REQUEST

Current Zoning: MUDD-O/I-2 (mixed-use development, optional & industrial)
Proposed Zoning: MUDD-O and MUDD-O SPA (mixed-use development, optional and mixed-use development, optional, site plan amendment)

Approximately 0.7 acres located SW of the intersection of Belmont Avenue and Seigle Avenue in the Belmont neighborhood.

SUMMARY OF PETITION

# RZ-1.0

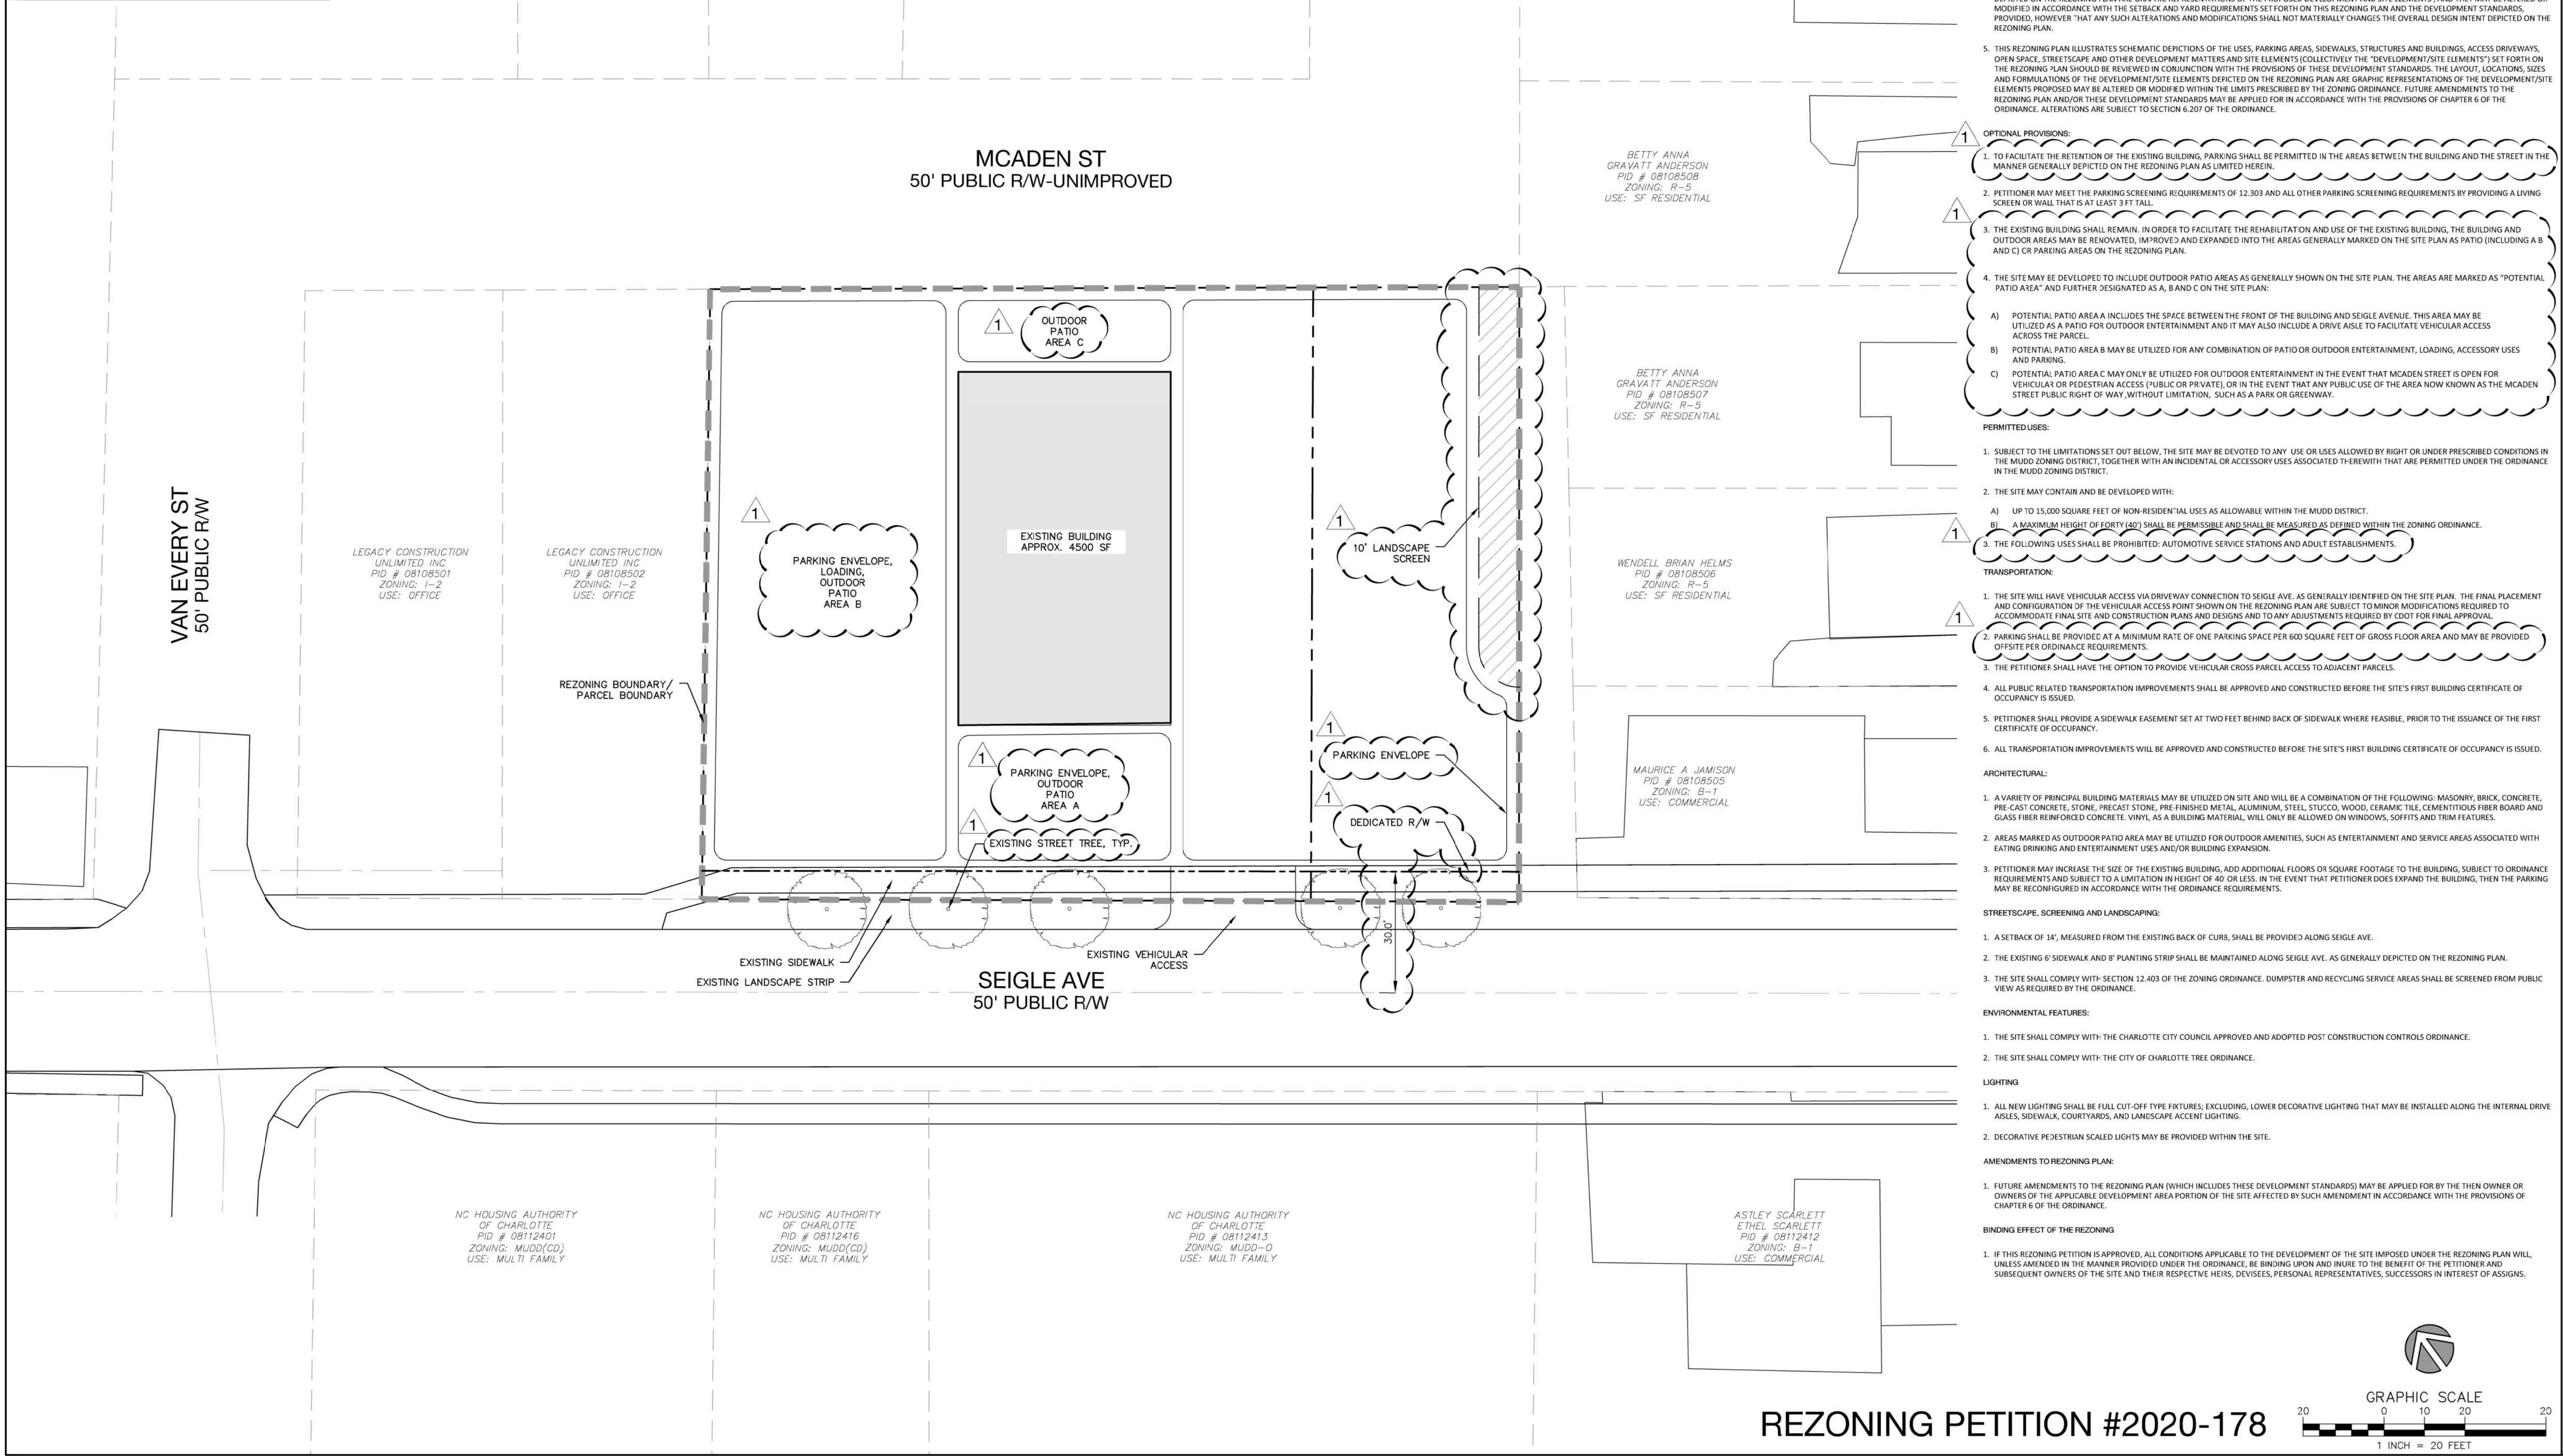
3. Please illustrate building envelopes for potential building expansion listed in conditional notes. This approach could be utilized to clarify the requested technical revision (9) below.

4. Remove parking provision in Transportation section (note 2). Shall be provided per ordinance.
5. Illustrate screening in areas outlined in site plan staff comments along the eastern and western property boundary.

6. Amend the minimum height of the proposed green screen to 4-feet in height; provide detail of green screen.
7. Please clarify that parking will comply with ordinance requirements and parking shall not be permitted between the street and any additional buildings/additions/improvements made to the site. Staff is comfortable only with permitting parking between the street and the existing building.

# RZ-1.0

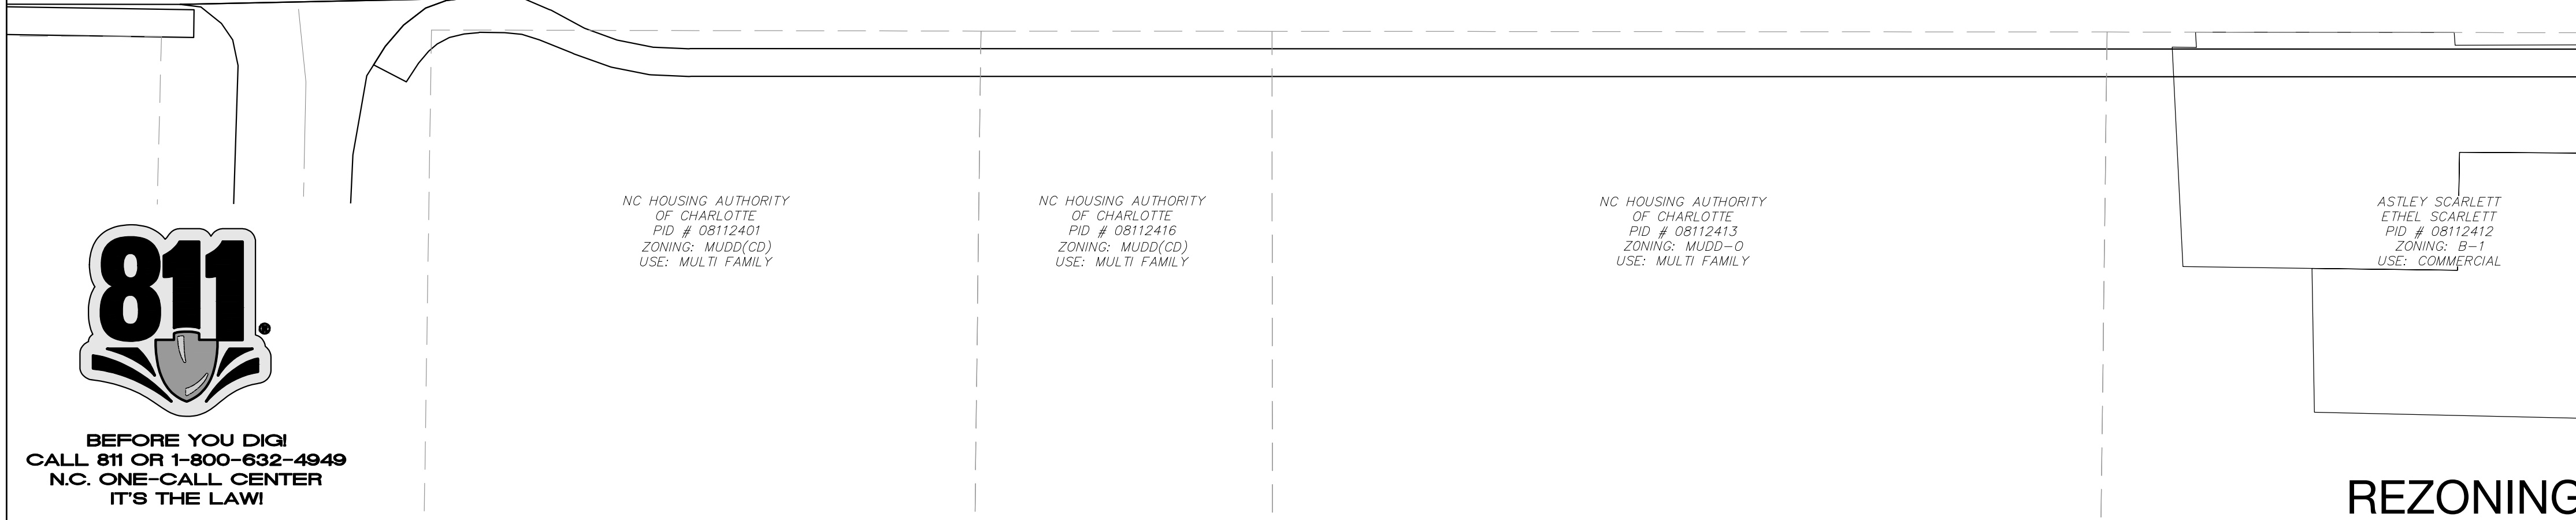
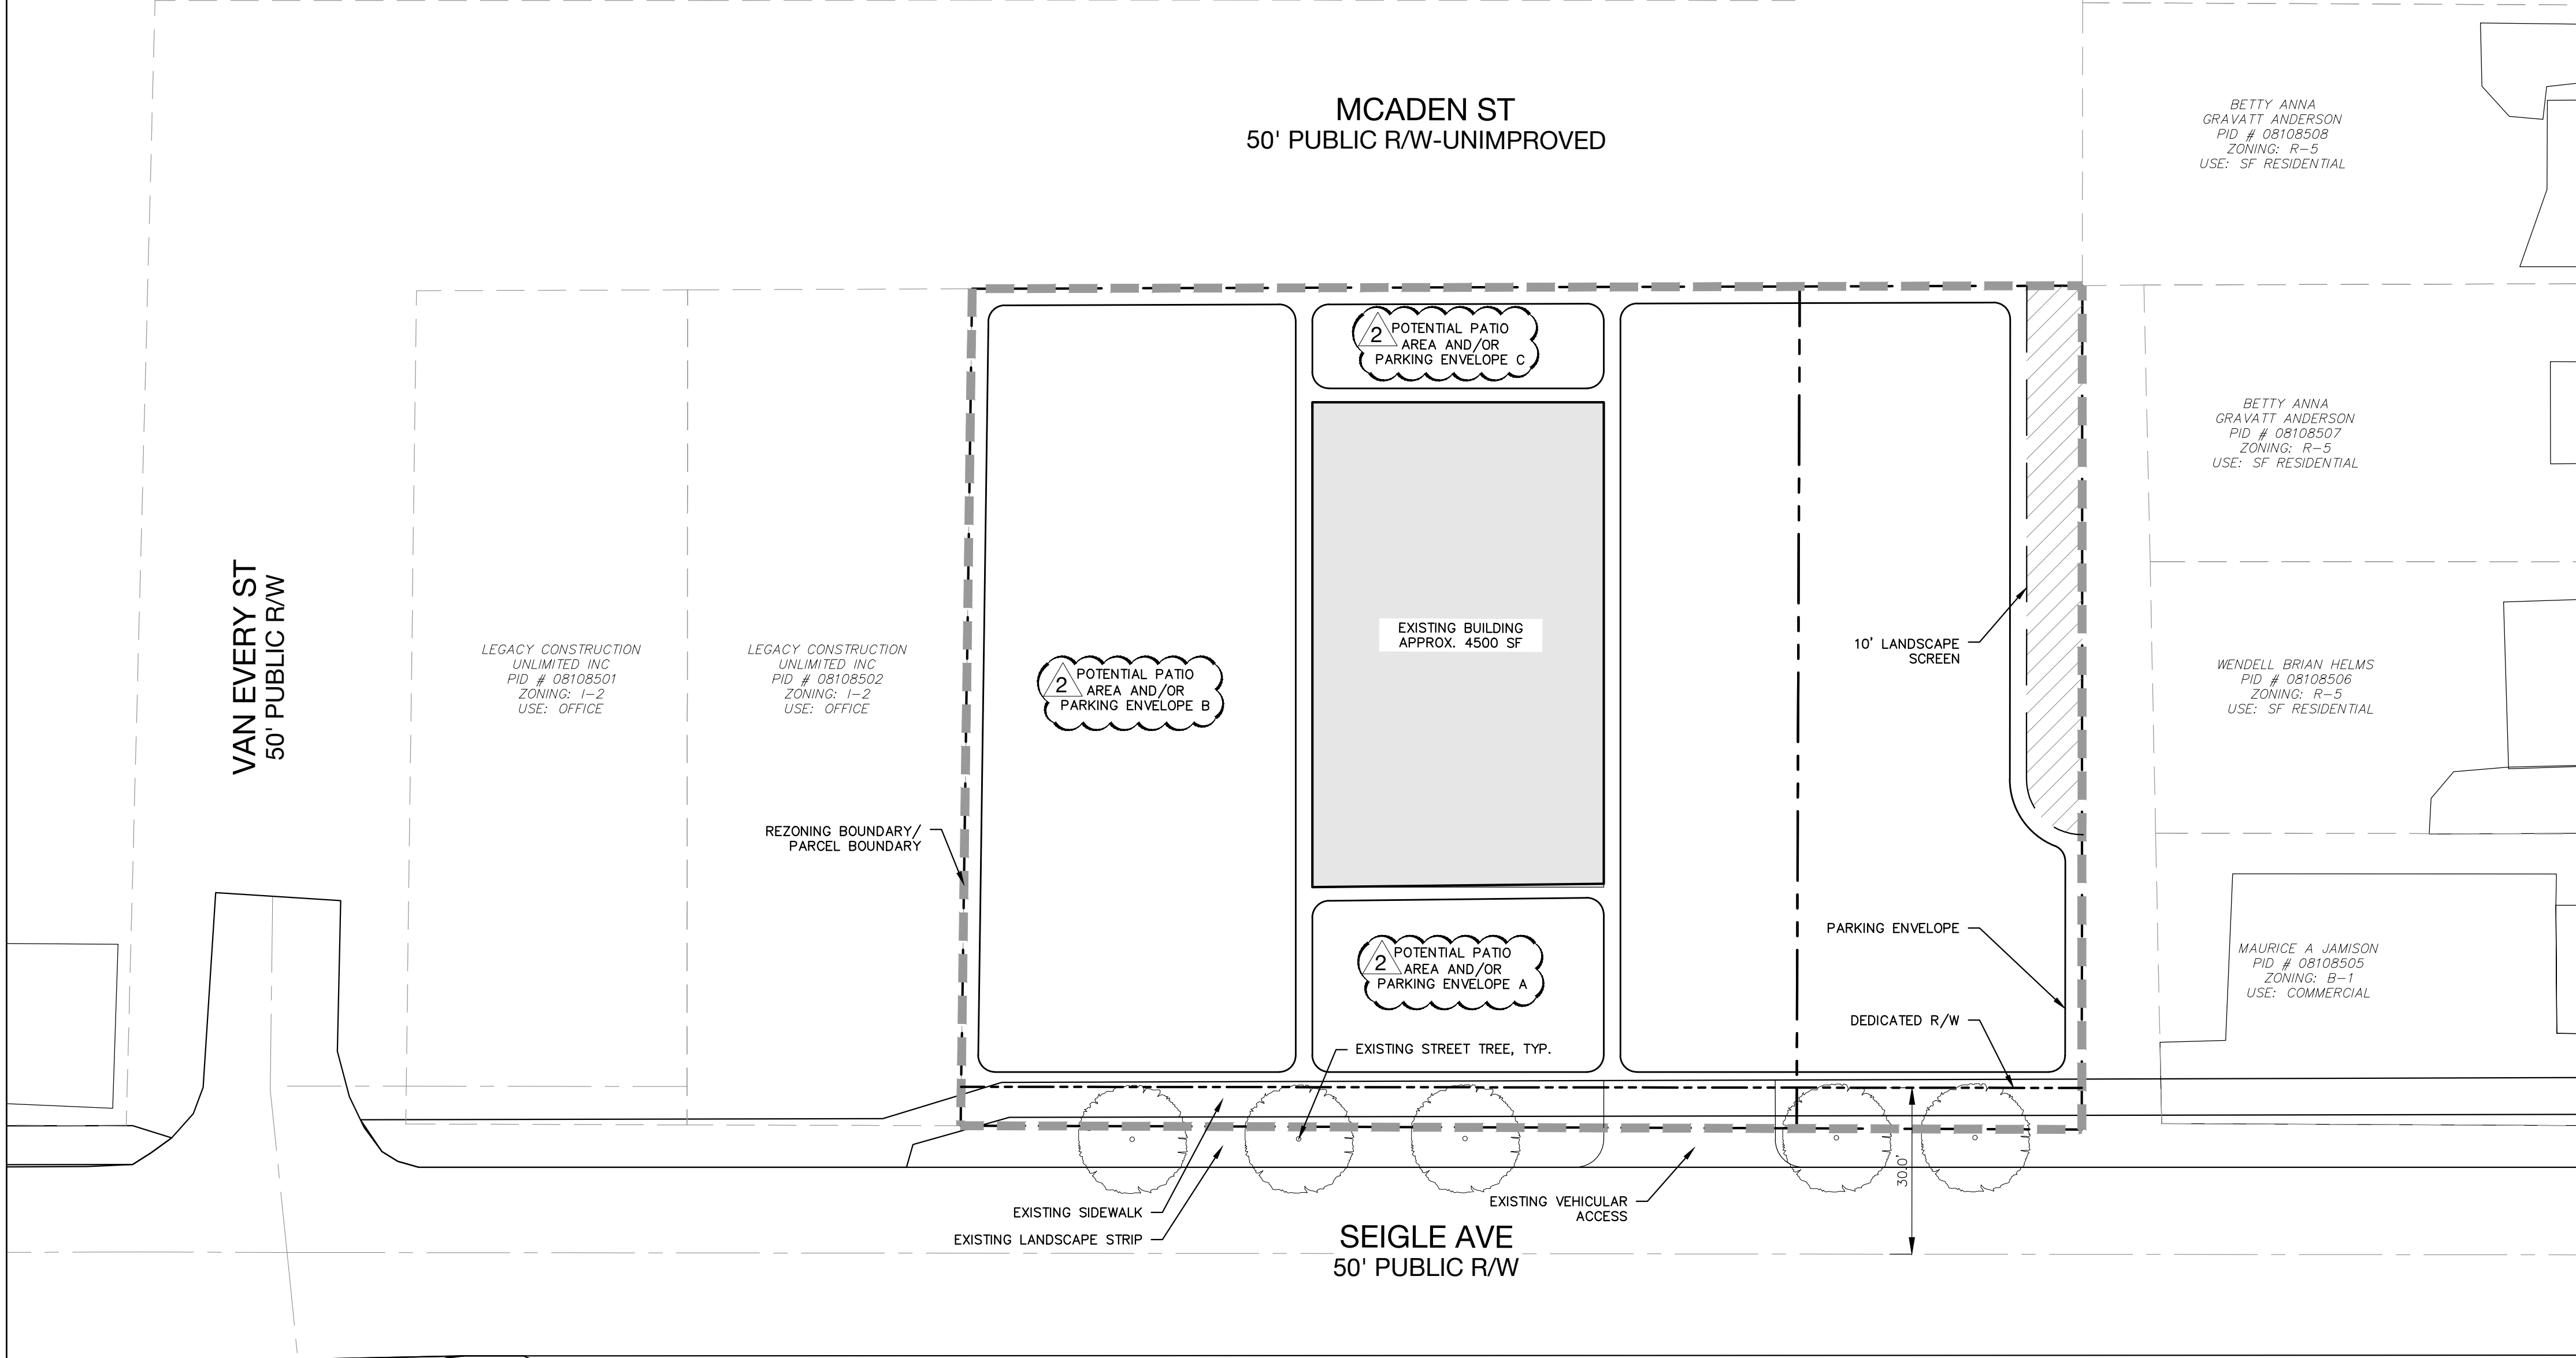
8. Adjust site development table to reflect parking required per ordinance and proposed building area up to 15,000 SF.
Please clarify/reword notes 3 & 4 in optional provisions to more clearly reflect the provisions being asked for patio/parking areas. This revision should also note or cross-reference the above outstanding issue 7 regarding the location of parking in front of any future improvements/additions.
